**Re: Chao/Limary Residence
6001 Buffalograss Ct NE
Request Permanent C.O. - Accepted
Engineer's Stamp dated: 6-8-15 (E23D003Q)
Certification dated: 8-3-15**

**Re: Chao/Limary Residence
Grading and Drainage Plan
Engineer's Stamp Date 9-17-14 (E23D003Q)**

**Re: Chao/Limary Residence
Grading and Drainage Plan
Engineer's Stamp Date 9-17-14 (E23D003Q)**

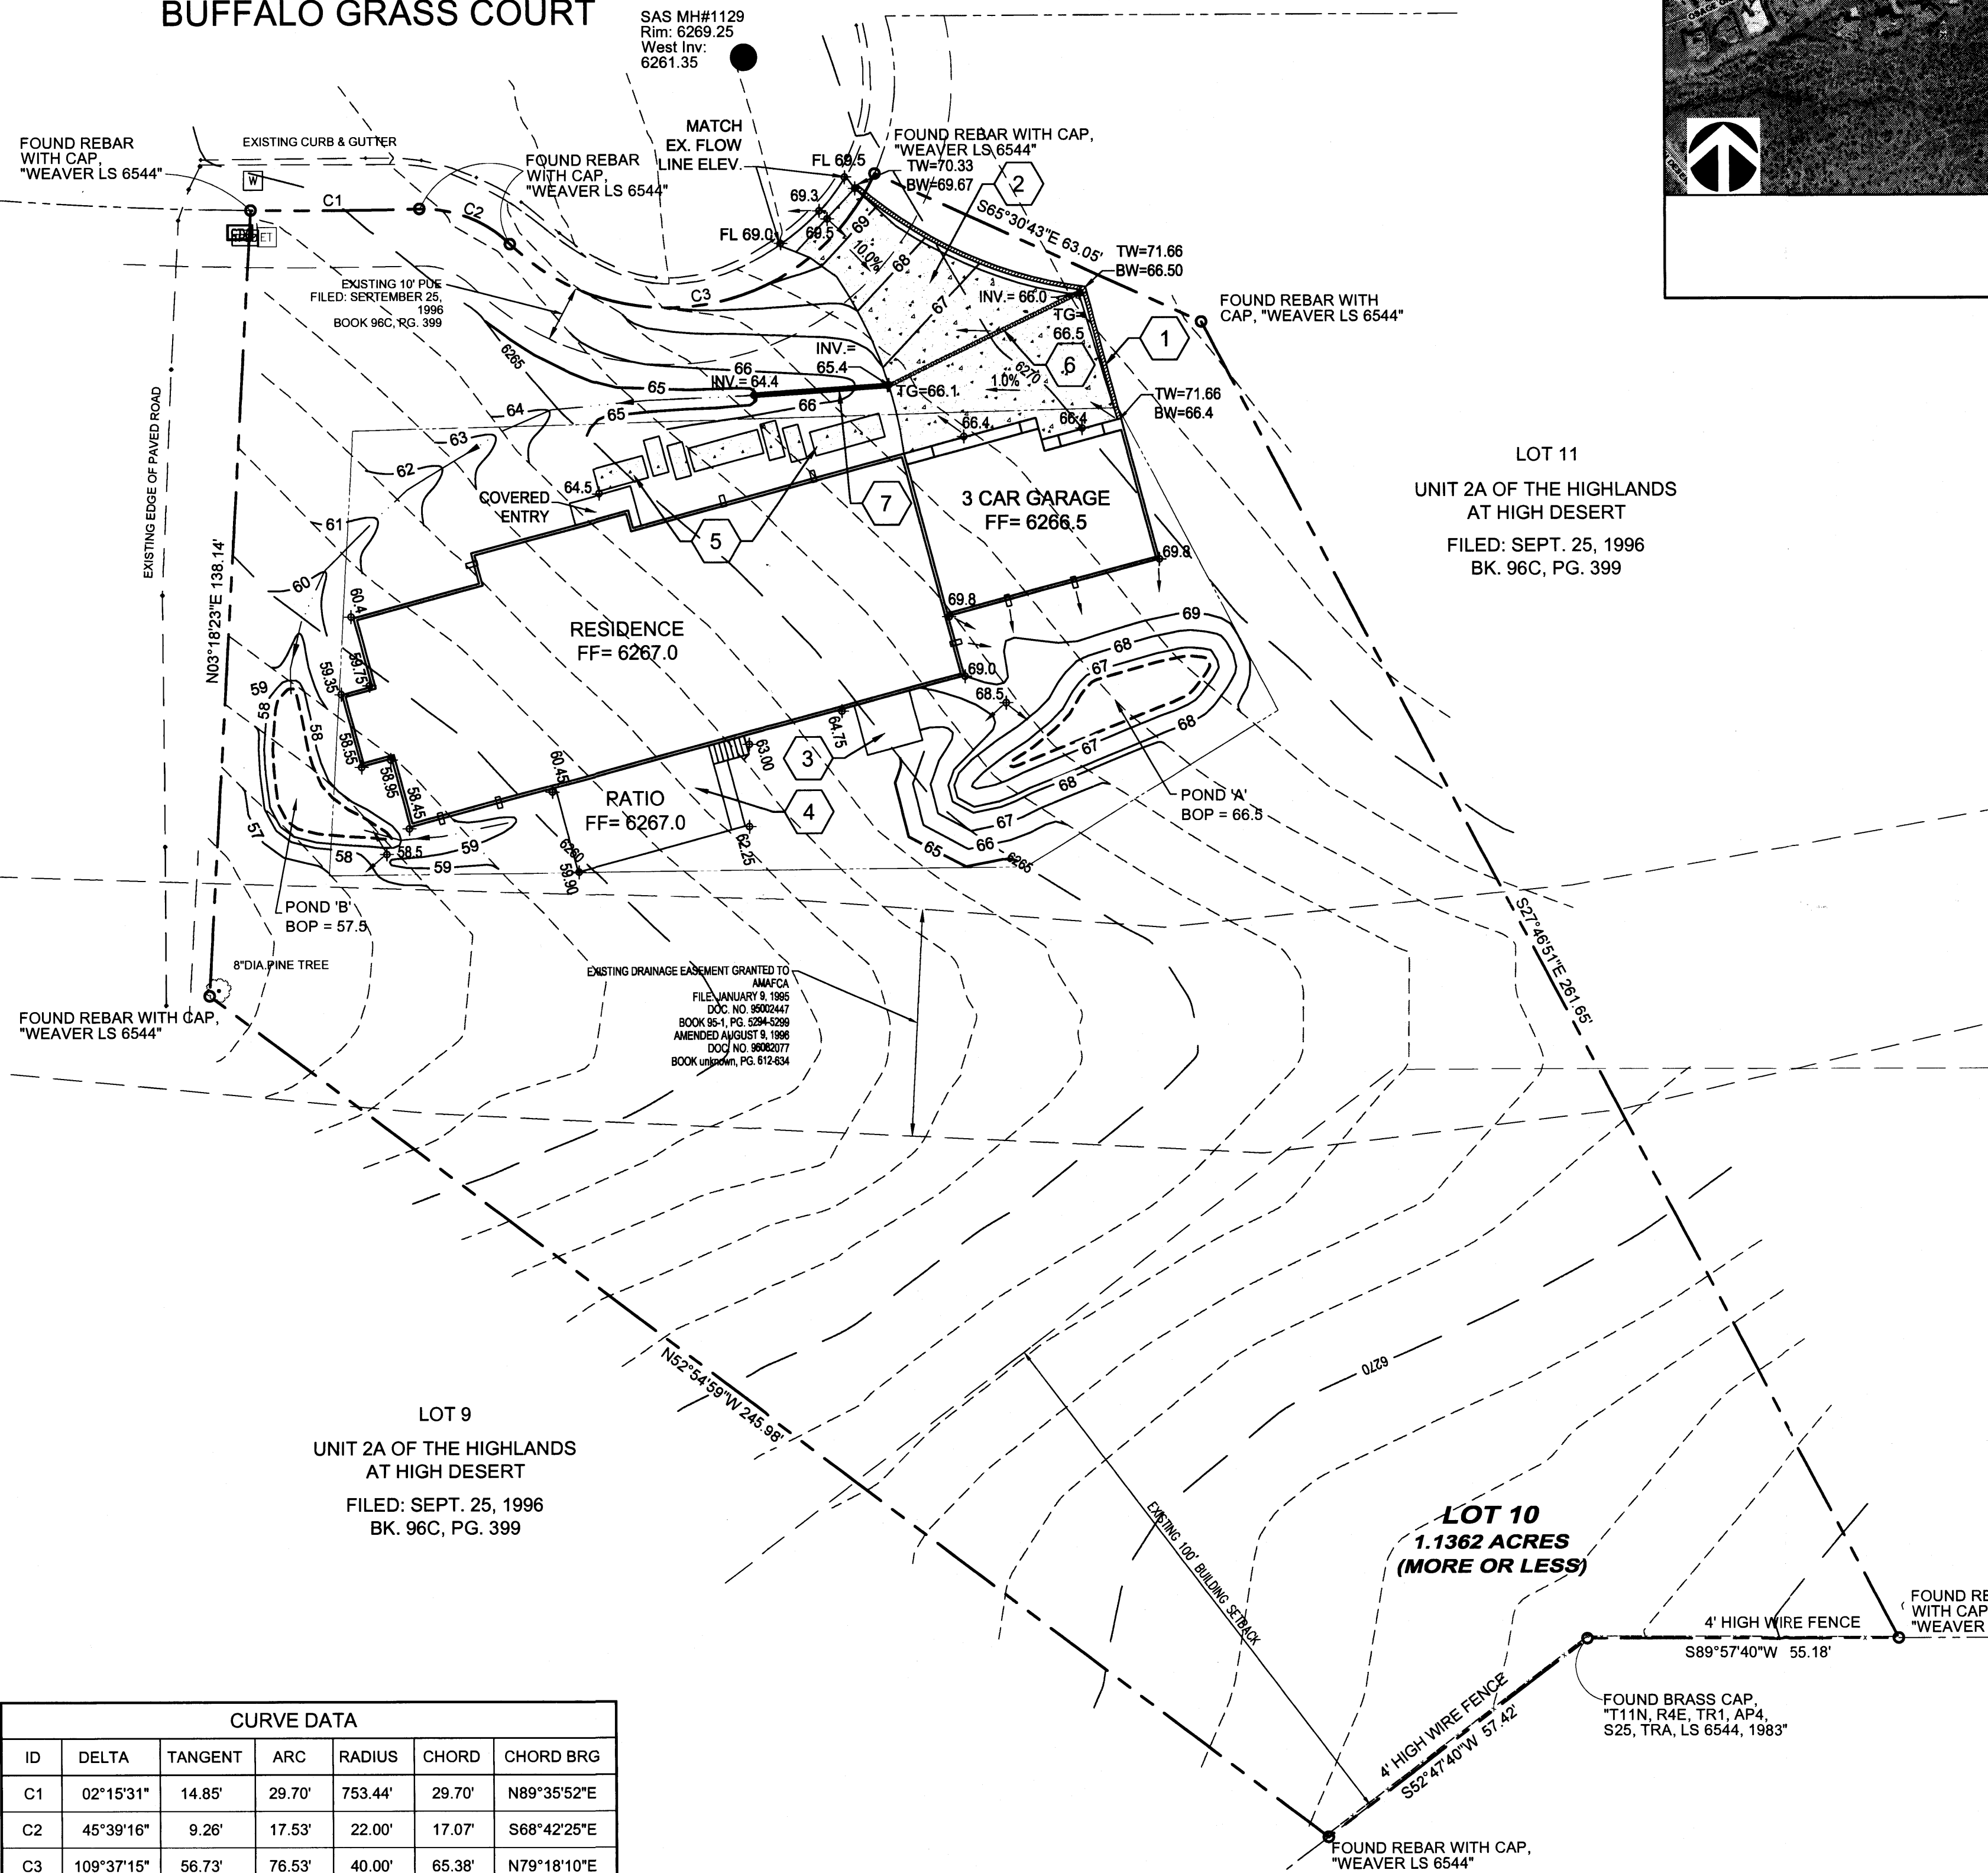
1. Provide a vicinity map with the site outlined on it.
2. Include a FIRM map and discussion of the Flood Zone the site is in.
3. A benchmark was provided. Is that a TBM? Identify it on the site or provide a tie to one if it is not on the site.

4. Provide a narrative. Indicate how the design of the property is in accordance with the Master Drainage Plan, High Desert – Tract 14B (E23D003K). Include a discussion of existing and proposed conditions off-site and on-site. Are flows coming from off-site? How are those being managed? Indicate all your existing and proposed design assumptions. Land Treatments B and C should be included for the proposed condition. The soil will be disturbed for the front yard, swale and ponds. There are slopes greater than 10% being proposed. See Table A-4 in Chapter 22 for the description of land treatments.

5. What is happening with the grades on the south and west sides of the property? There is a drop of 9 feet from the house to the pond on the west, but no wall of any kind indicated. On the south side, what are the grades against the house? How are the proposed grades being tied into the existing grades on the south and east sides? What are the grades for the patio and deck? Show any stem walls and grades adjacent to the stem walls.

6. What are the flow line elevations in the cul-de-sac that are being matched? Is the higher side of the proposed driveway going to be above that for the full length of the water block? Is there enough of a water block to prevent flows from entering and going down the driveway?

- ✓7. Show the entire property. Provide a second sheet if necessary.
- ✓8. Discuss how the First Flush is being retained. Per the City Drainage ordinance, the 90th Percentile Storm Event, which is 44 inches, is to be managed. Reduce 0.44 inch by the 0.1 inch for the initial impervious abstraction in Table A-6 of Section 22 of the DPM. Multiply the remaining 0.34 inch by your impervious area. This is the portion to retain.
